**Multi-storey Carpark at Westmead Hospital (SSD 7262)
Notice of Exhibition**

Thank you for your letter dated 10 December 2015 requesting Transport for NSW (TfNSW) comment on the above proposal for an eight-storey, 1254 space carpark.

TAB A – Request for Further Information/Clarification

DRAWING TITLE:
CARPARK SITE PLAN

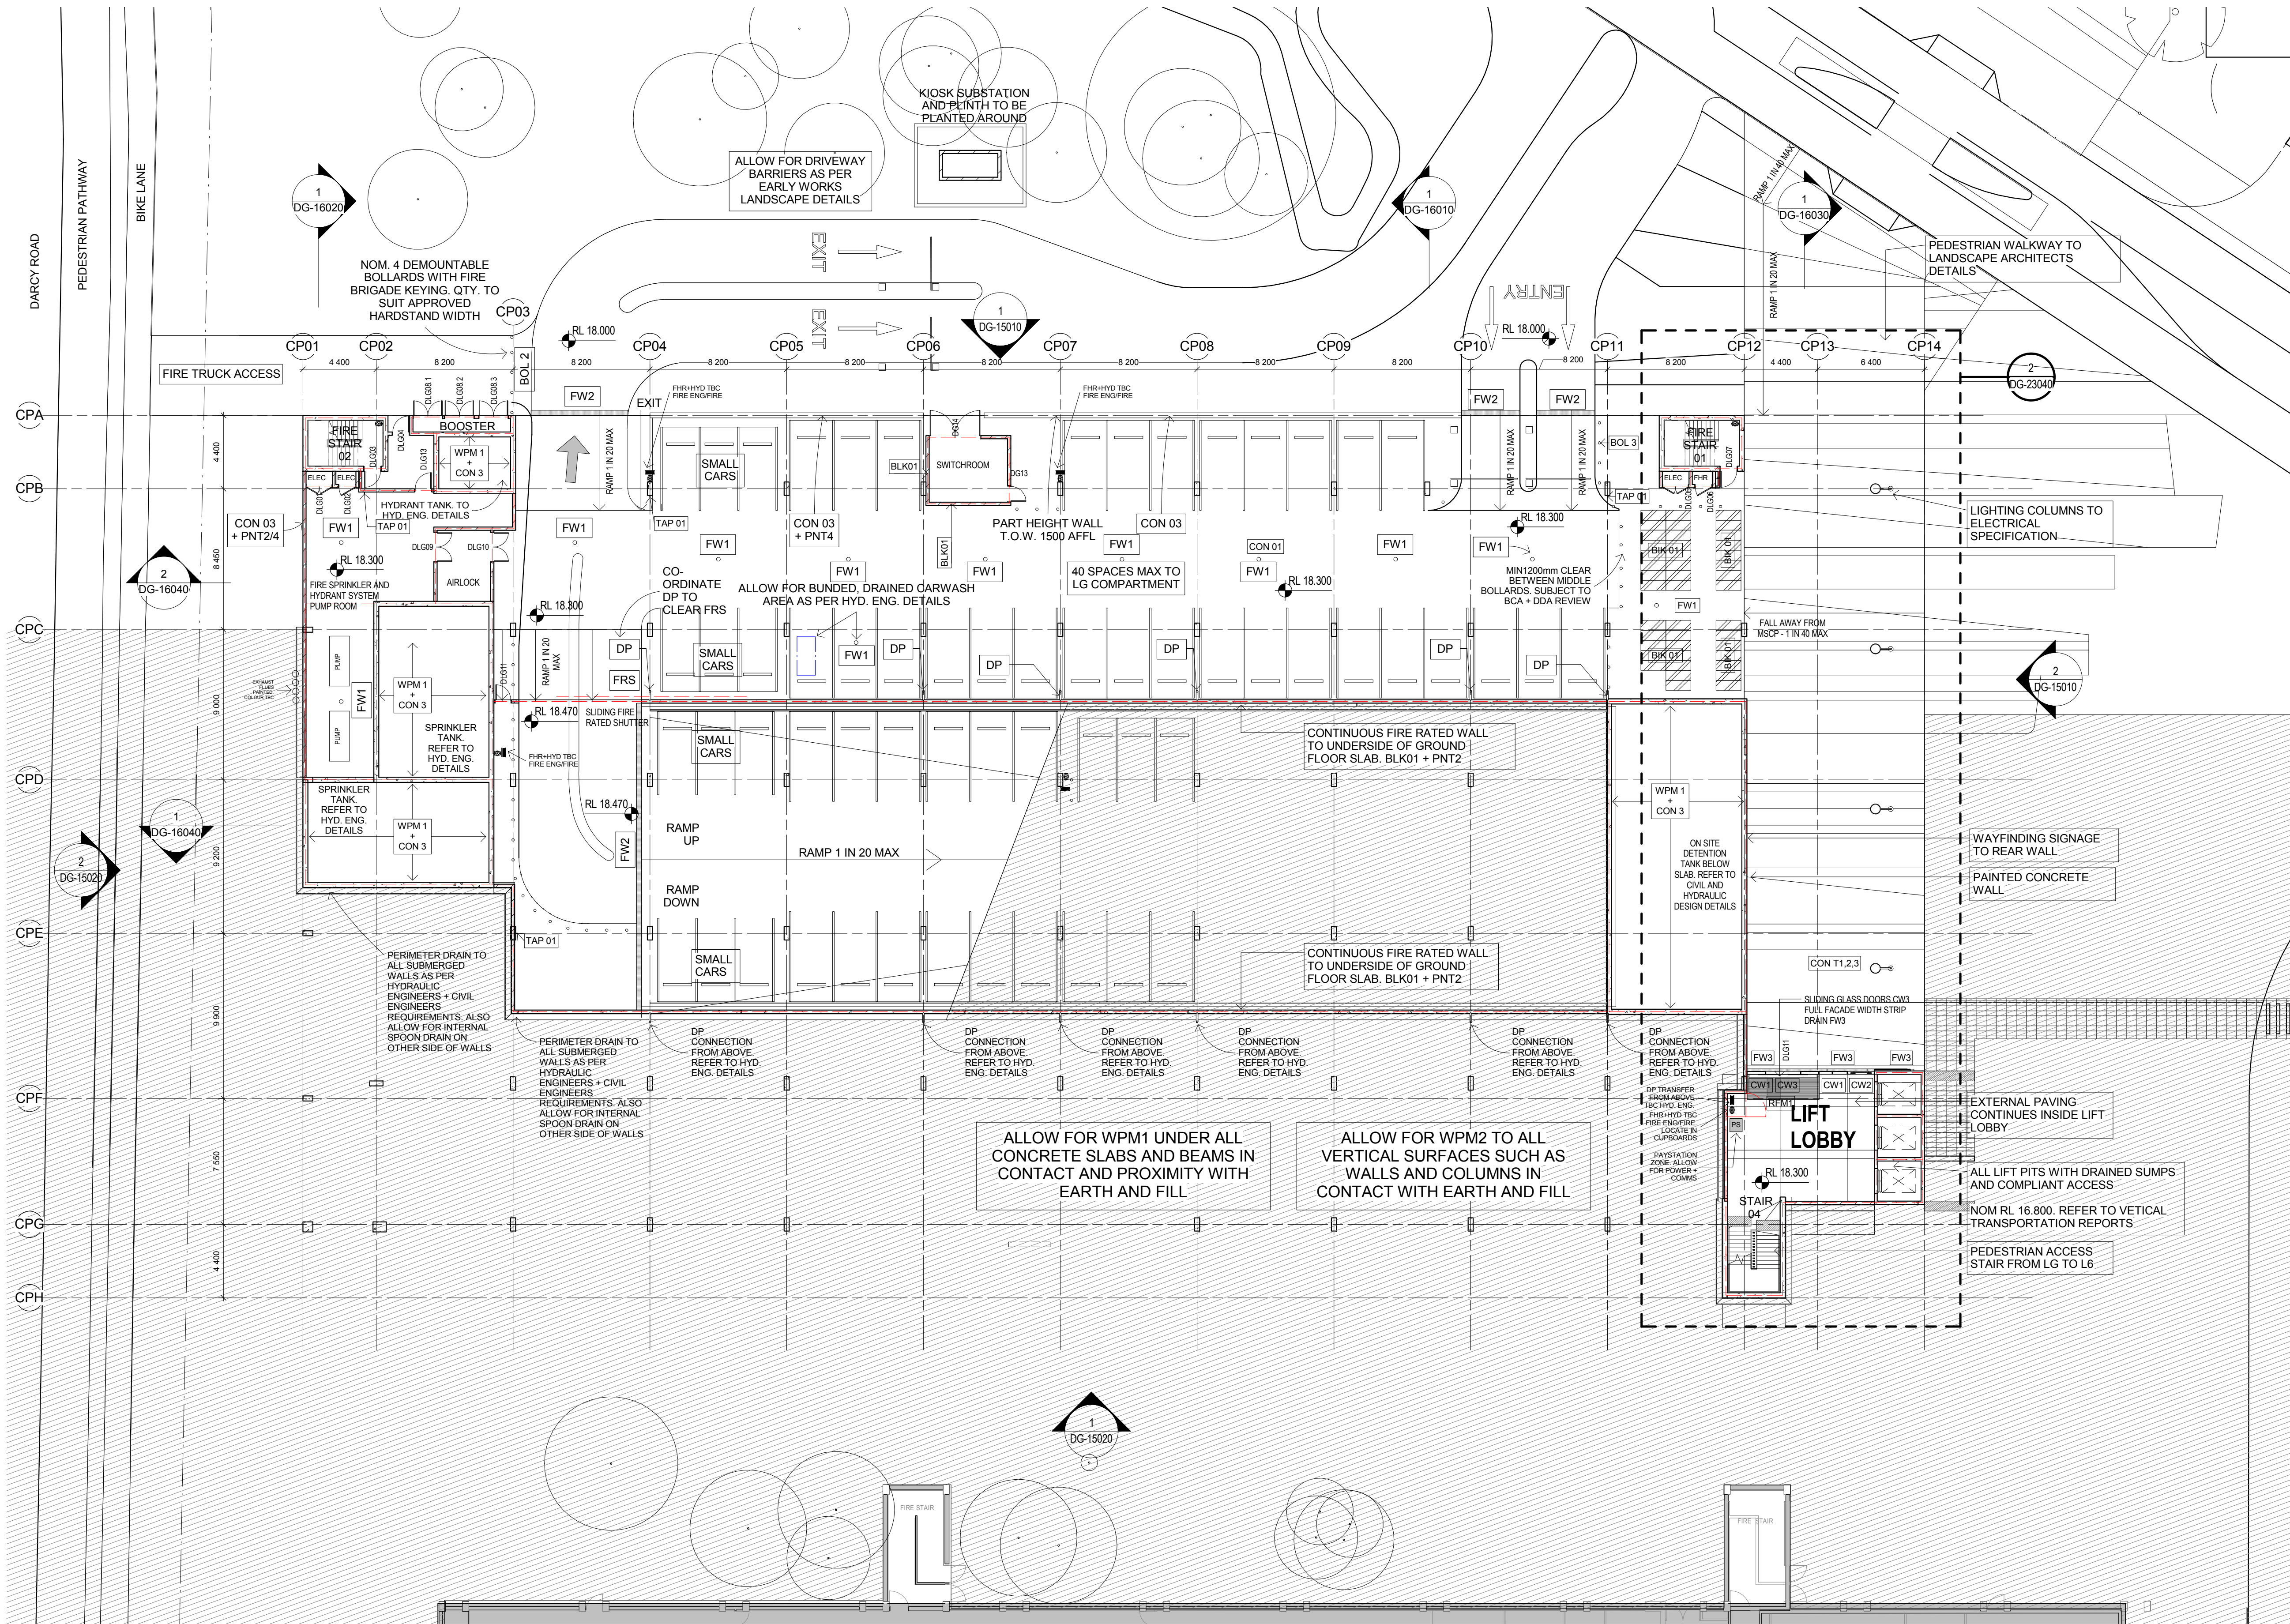
It is important that the carpark access is designed with entry capacity to ensure that queuing does not block through traffic on Darcy Road and Institute Road as this would have a significant impact on the operation of Darcy Road and the T-Way.

The car park access proposed includes two Entry lanes from Darcy Road, one Entry lane from Institute Road and two Exit lanes onto Institute Road. The TIA indicates that the number of access points has been reduced due to the implementation of Automatic Number Plate Recognition (ANPR) system. As a result the service rate of 550 veh/h/lane has been used for assessment, which is close to free flow (i.e 600 veh/h/lane). It is unclear how such a high service rate can be achieved considering the system seems to indicate boom gates would still be required as shown in Figures 7.5 and 7.6.

It should be noted that the entrance to this development from Darcy Road crosses the T-Way separated cycleway. It appears that the documentation presented, does not include measures to reduce potential conflict between car park users and cyclists traveling along the cycleway.

- Wayfinding signs be provided to increase the awareness of the walking and cycling routes;
- The potential for cars queuing to access the car park, which could block the cycleway should be investigated and suitable measures implemented to appropriately manage the issue; and
- The provision of accessible car parking spaces be reviewed in accordance with relevant standards and guidelines.

- The operation of the ANPR system be further clarified with the claimed service rate justified by empirical data; and
- Appropriate measures be put in place aimed at ensuring queueing at the access point during peak events do not affect traffic and buses on the road network and the T-Way. The measures should be incorporated into a carpark management plan.
